Project: I5719B – U5800 Design Build

Subject: Hydraulics CP4B Meeting - Minutes

Date: Wednesday, April 15, 2026

**PERMIT DRAWING
SHEET 12 OF 49**

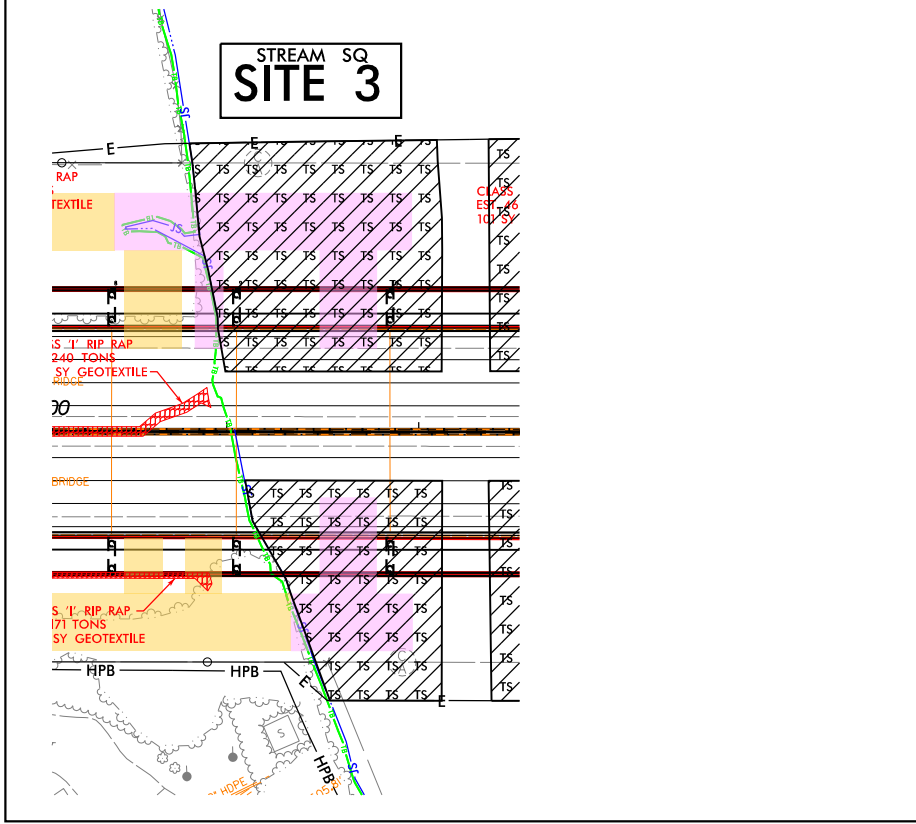
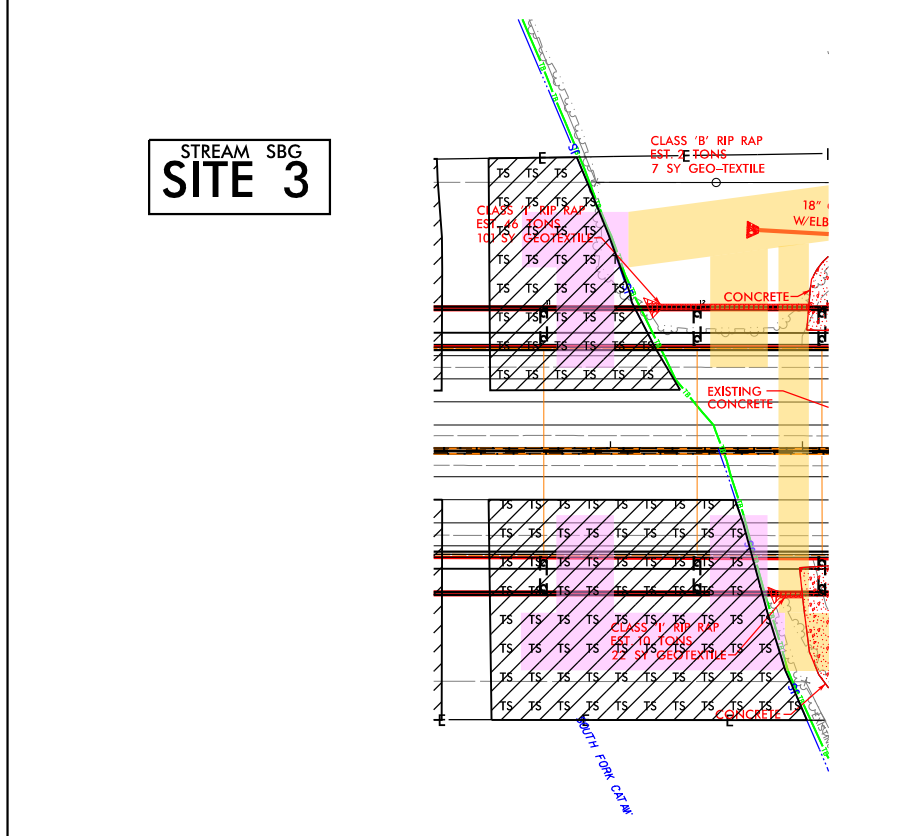
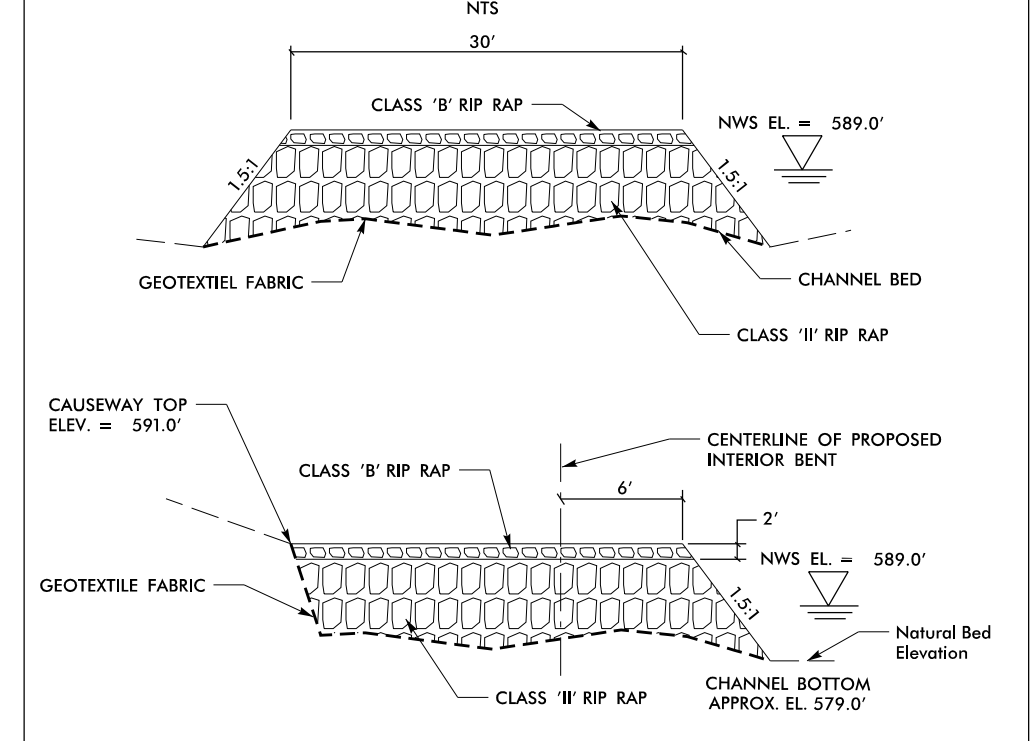
- Stream SQ – South Fork Catawba River
  - Widening existing bridge to the outside on both sides
  - Impacts from temporary rock causeway construction methodology for bridge widening – modeling included in BSR – no increases up to and including 100-year. Minor increases for 500-year. No structures impacted.

- Due to shallow rock line and limited water depths in the river, work trestles and barges are not viable construction methods
  - Contractor is looking at rock causeways for construction access-two left causeways concurrently, two right causeways concurrently all within existing ROW.

- Crystal Amschler – Good with the design because the causeways are less than 50%.
  - We will have drawings at 4C showing the temp impacts.
- There are currently existing deck drains discharging directly into the river which will be retained during construction. The drains that are over water will be plugged in the final condition.

**STREAM SBI
SITE 4**

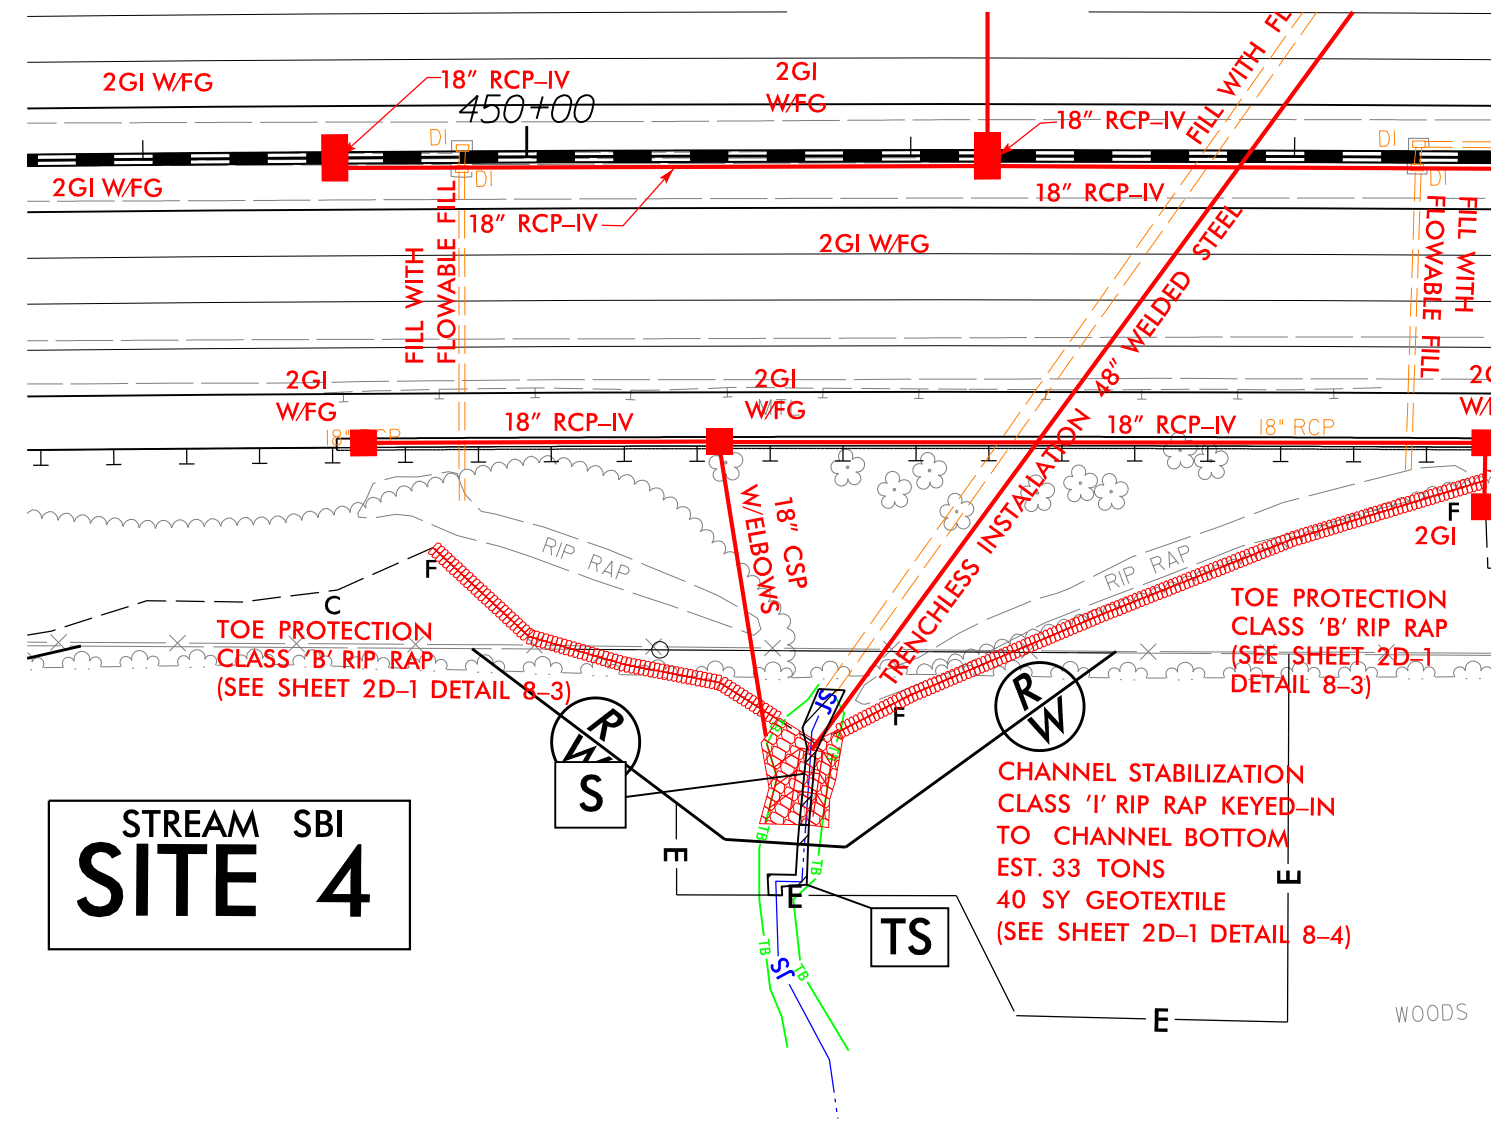
- Stream SBI – UT to South Fork Catawba River
  - Existing 36" CMP
  - Replacing with 48" Smooth Steel Pipe
    - Currently not showing buried
    - Pipe slope = 5.3%, Vel<sub>10</sub> = 19+ fps
  - Upstream
    - Not Jurisdictional Upstream
    - Potentially a spring as primary source of water
  - Downstream
    - Tying in Roadway drainage to the stream
    - Showing Rip Rap keyed into the bottom of the channel
- No impacts to Stream SBH on this page
- Bill Barrett – small stream at inlet side.
- Crystal Amschler – no concerns about pipe built at grade.

WETLAND WXB
SITE 7

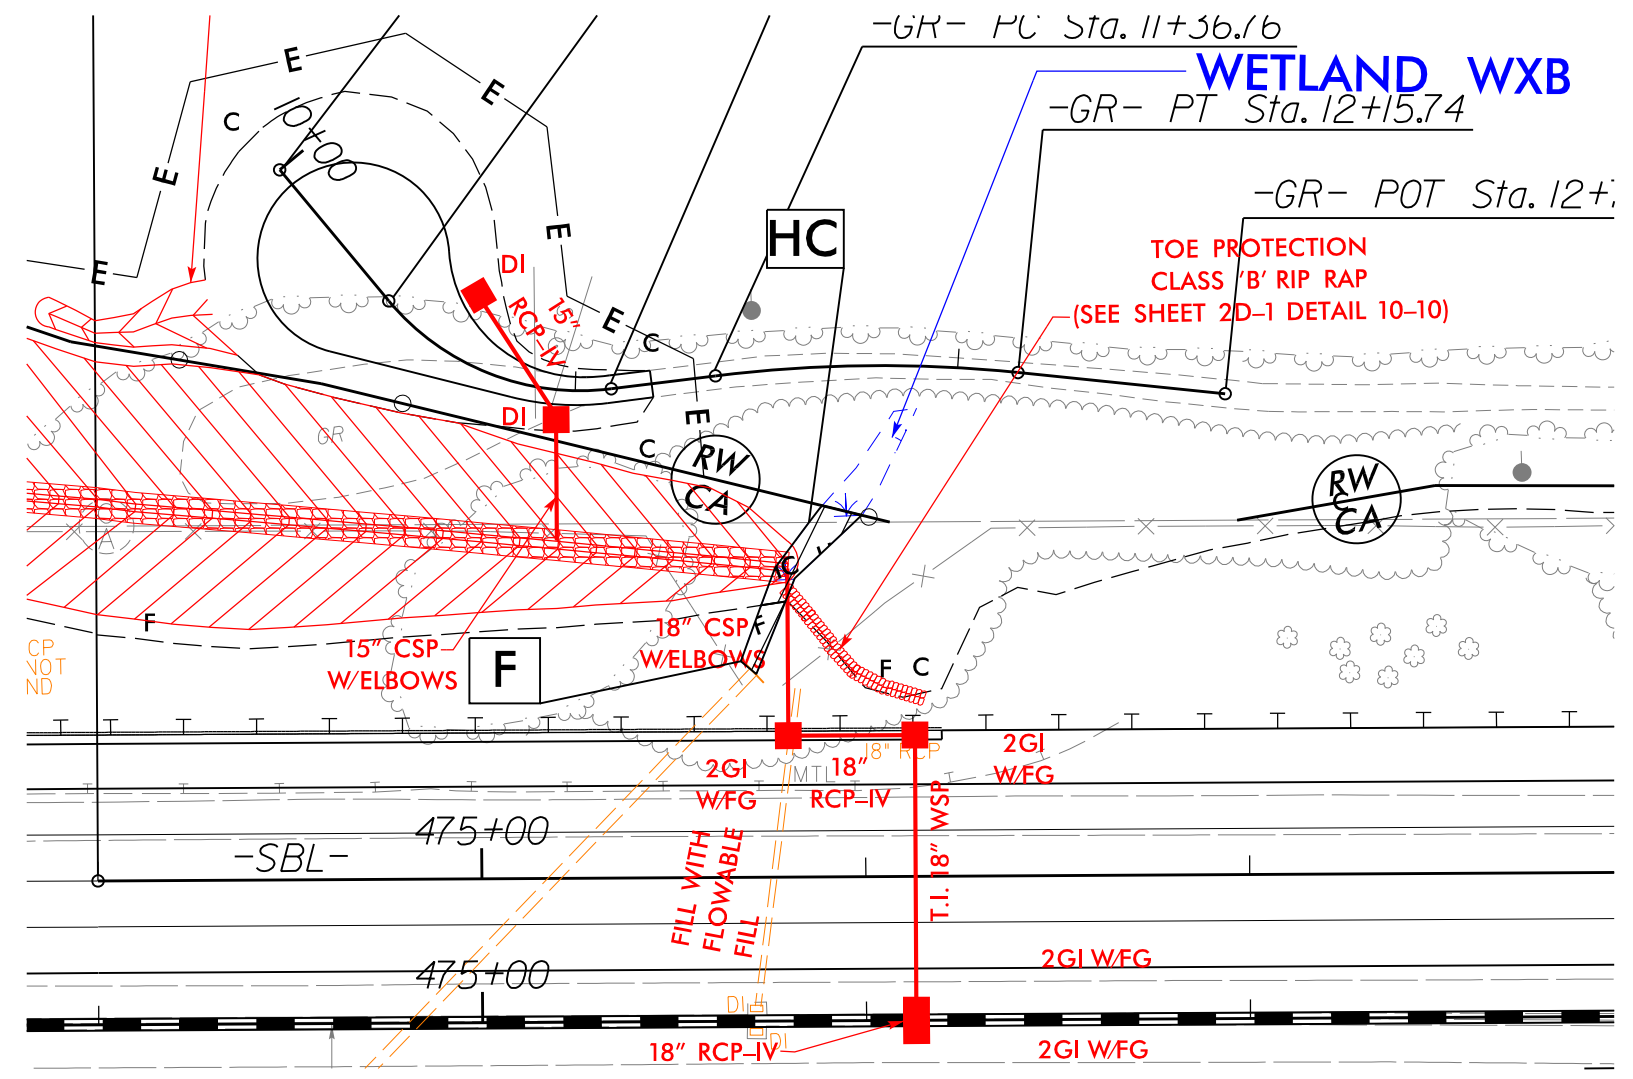
- Wetland WXB
  - Small wetland at the inlet of the existing 30" RCP to be removed
  - Do not anticipate a big impact due to the proposed design. Not likely for a total take

- Bill Barrett asked if we would be changing hydrology of the wetland. It is an existing swell and remain as is. There are direct impacts. Crystal was curious if there was an elevation change or a drainage effect. She said to keep an eye on to make sure it isn't drained.
- Wetland WXA
  - Small wetland at the inlet of the 24" RCP
  - After impacts due to widening and bore pits for new 54" pipe, most likely a total take
- **Total take of WXA**

PROFILE ALONG EX. 8x8 RCBC – SITE 9

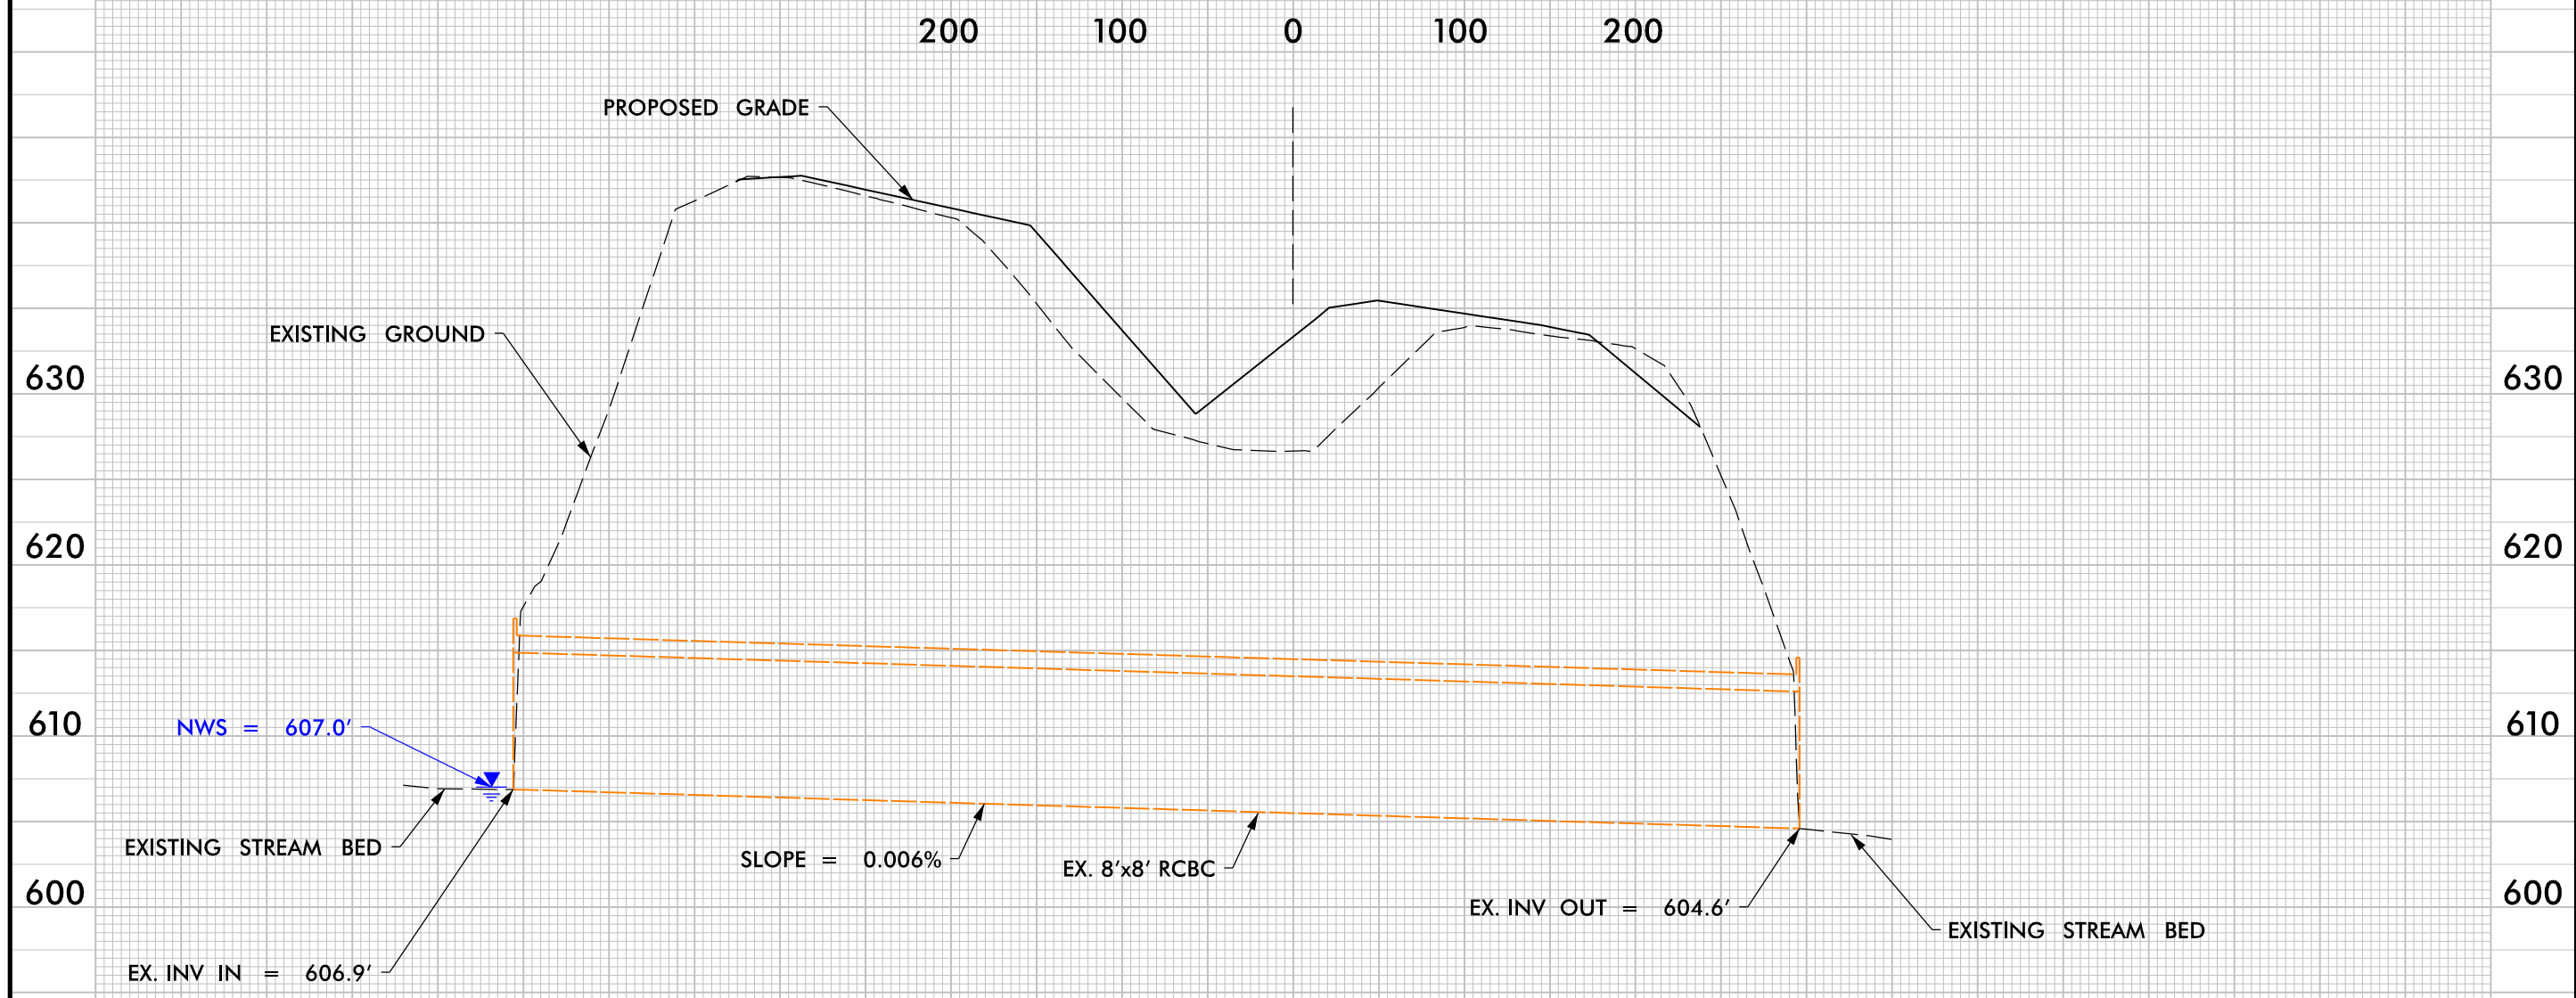
- Stream SO – UT to South Fork Catawba River
  - Existing 8X8 RCBC
  - Retaining Existing
  - Upstream
    - Adding Bank Protection approximately 35' upstream
    - No rip rap in bed of the stream
  - Downstream
    - Adding Bank Protection approximately 30' downstream
    - No rip rap in bed of the stream
    - Vertical bank on left side downstream
  - Tying median inlets back into the middle of the culvert
  - Current culvert is not buried and does not have any sills
